**Consultation Response from Mike Hibbert,  
KC Waste Strategy( Refuse & Recycling)**

**2024/90501 Clifton House Surgery, 1, Church Street, Golcar, Huddersfield, HD7 4AQ**

**Prior notification for change of use from commercial/business/service to one dwelling (within a Conservation Area)**

**Responding Ref: WPS 24-012**

3-065-05

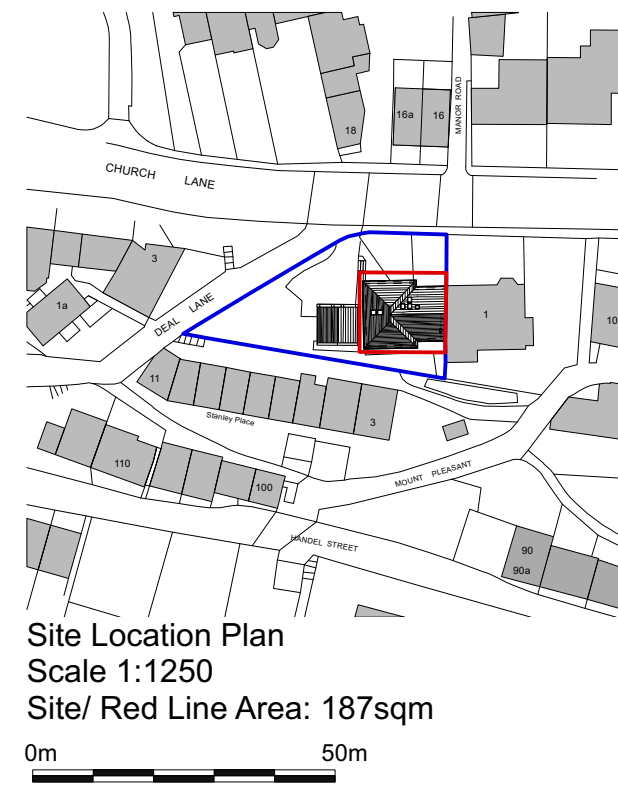
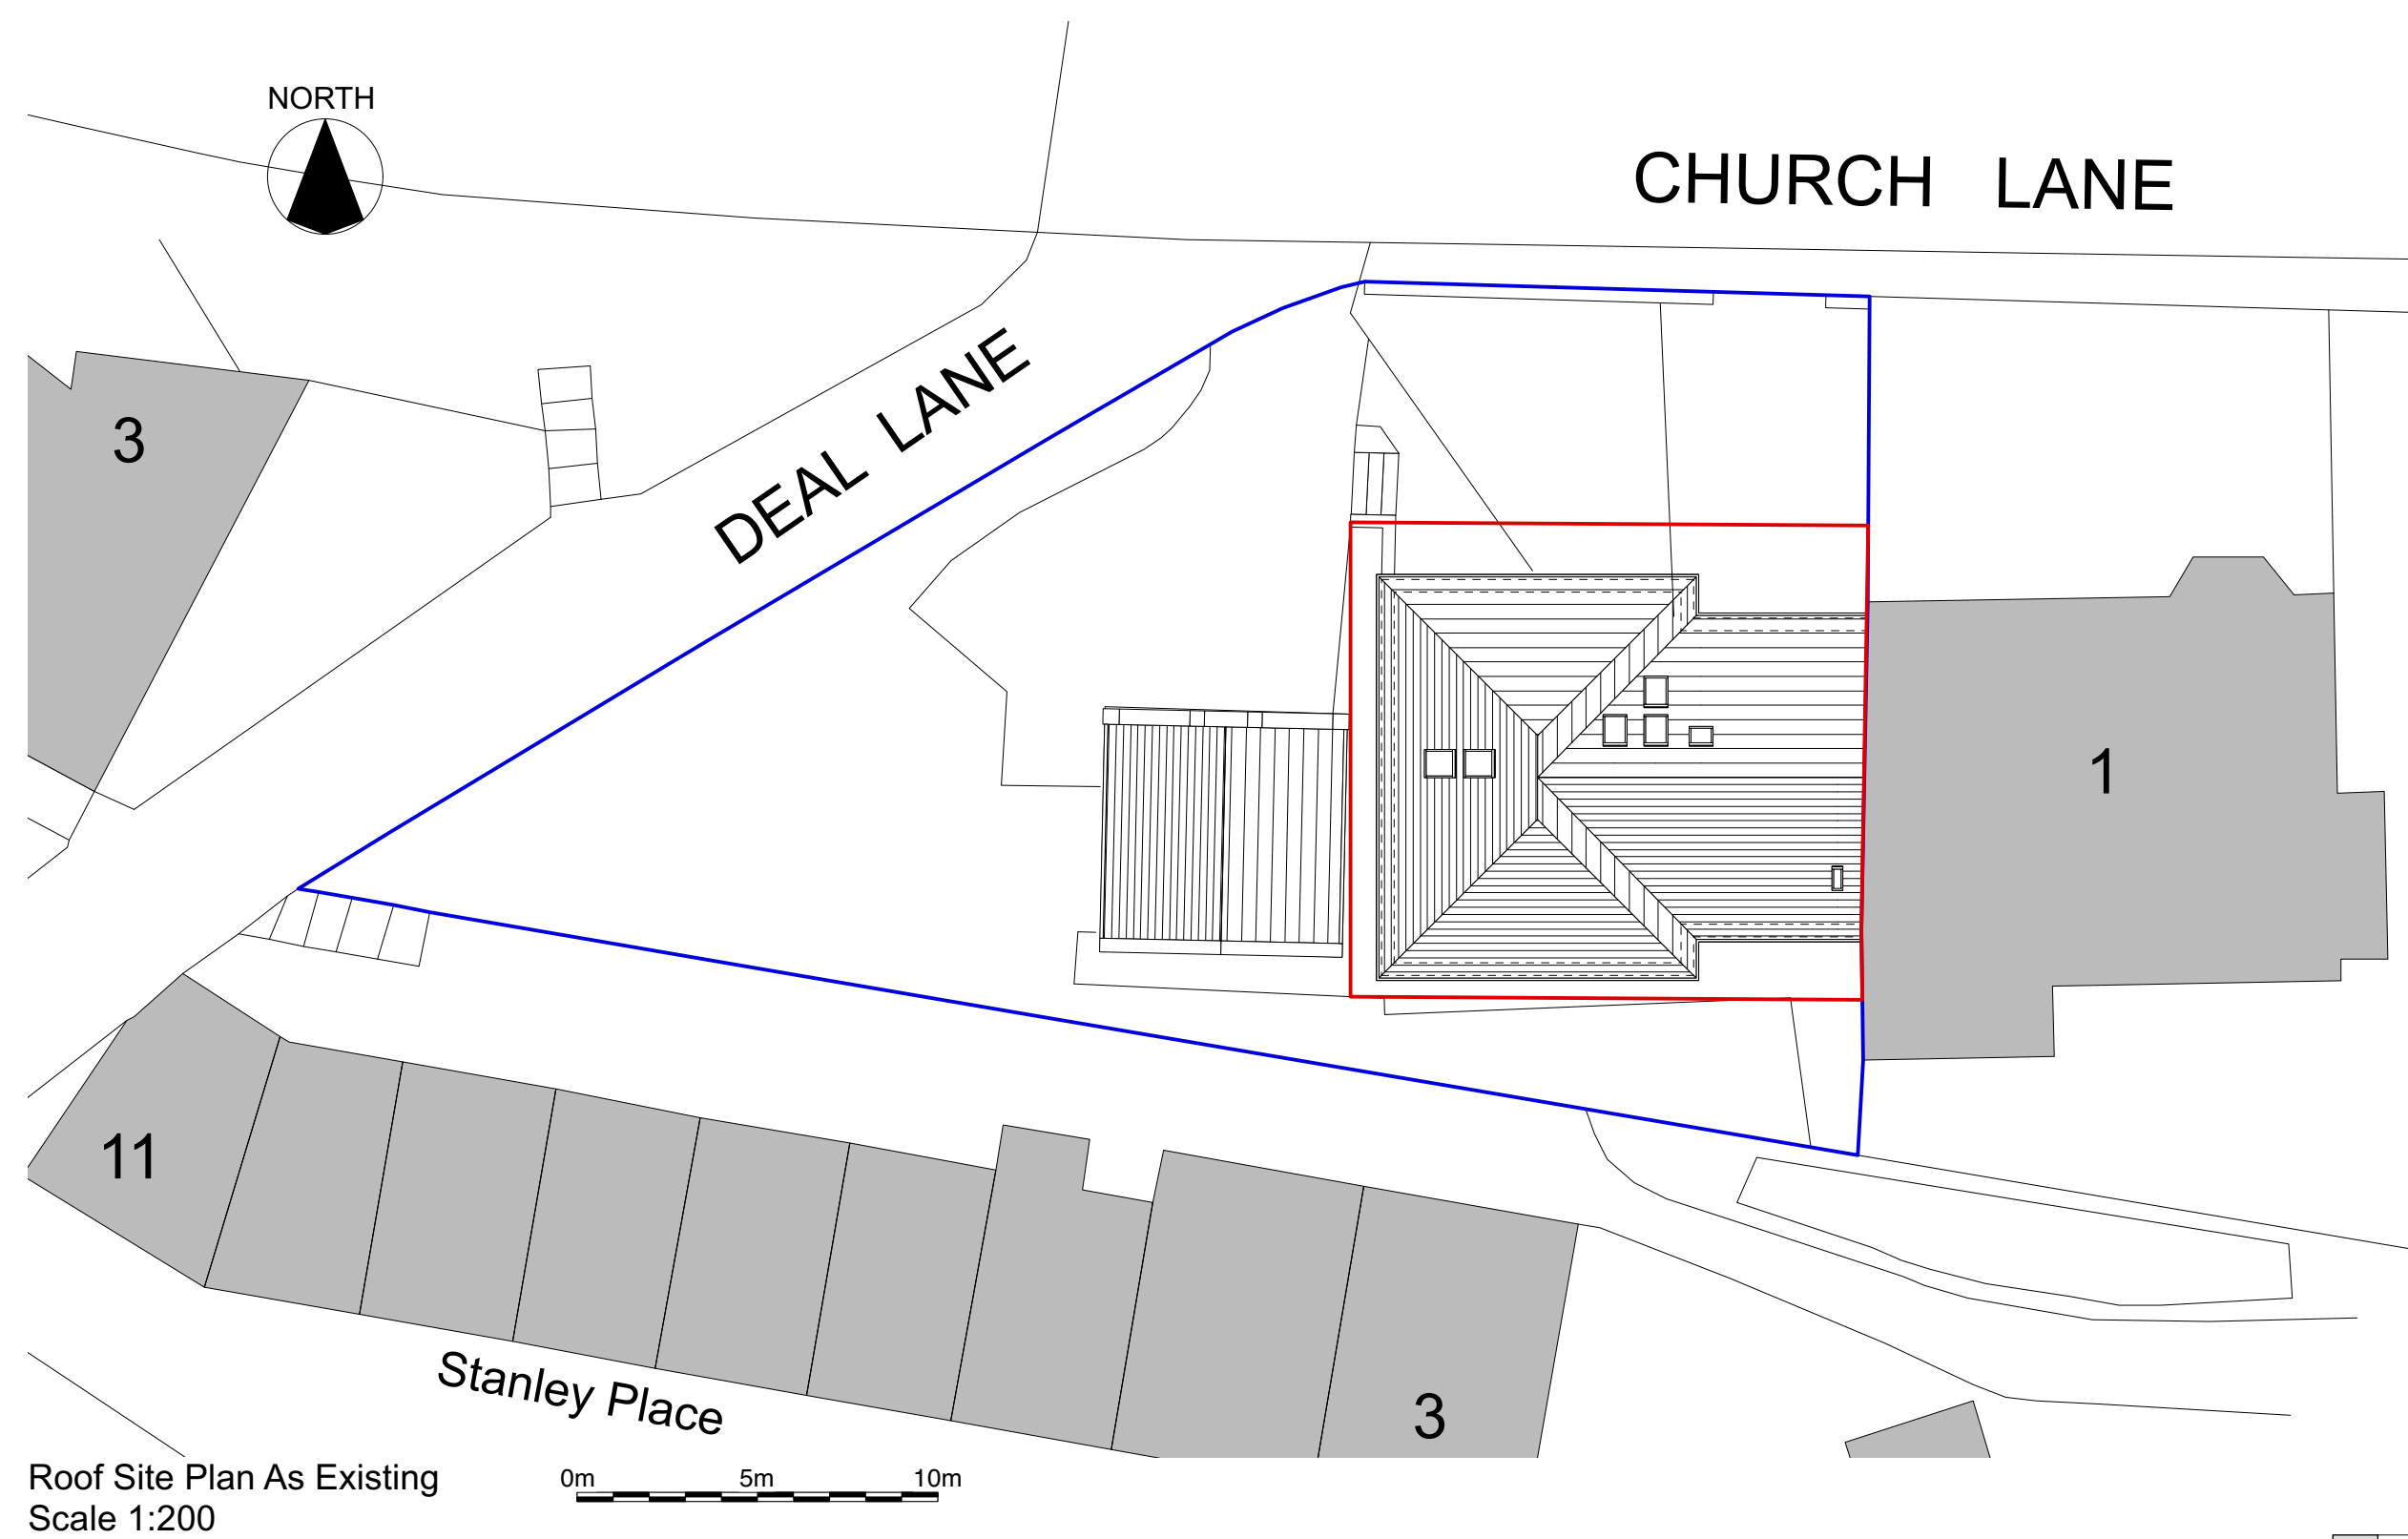
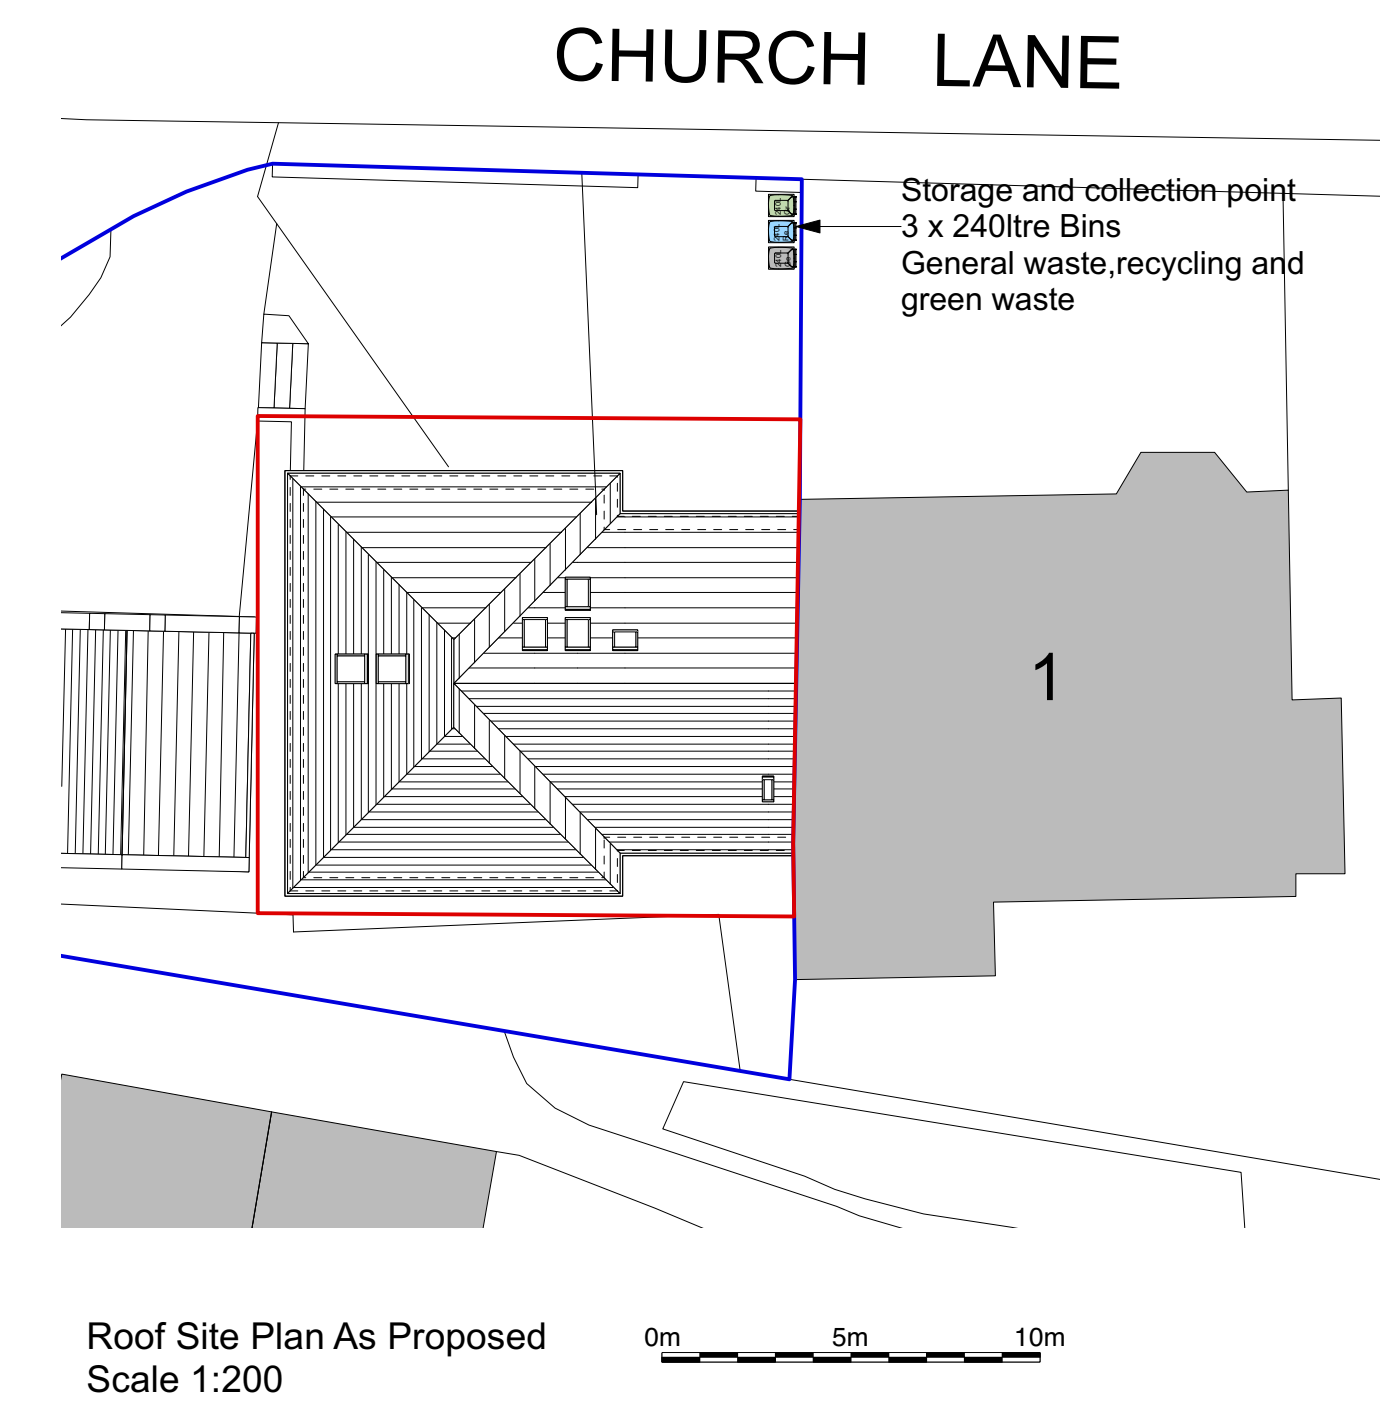
- Due to the split-level nature of the site, there will need to be bin storage to the front of property. There is no bin store shown on the plan. There should be sufficient space available within the curtilage to accommodate three bins. Guidance indicates the storage footprint for a 240ltrs wheeliebin is 940mm x 780mm with enough room to allow removal of the bin from the storage location.

- There is no indication of space for the presentation of bins on collection day. It is important to ensure that bins do not cause obstruction to pedestrians or other highway users when presented for collection. Bin presentation space should be identified within the plot, on a hard surface and where a refuse collection vehicle (RCV) can be easily reached. Guidance BS5906:2005 specifies that the maximum drag out distance from the property to the Bin Collection Point (BCP) is 25m and this is achievable with the site layout as shown. Likewise, the drag out distance from the BCP to an RCV will be within guidance distance.

- The bin store and BCP can be combined if located adjacent to the highway/ drive entrance and would be screened from Streetscene by the stone boundary wall.
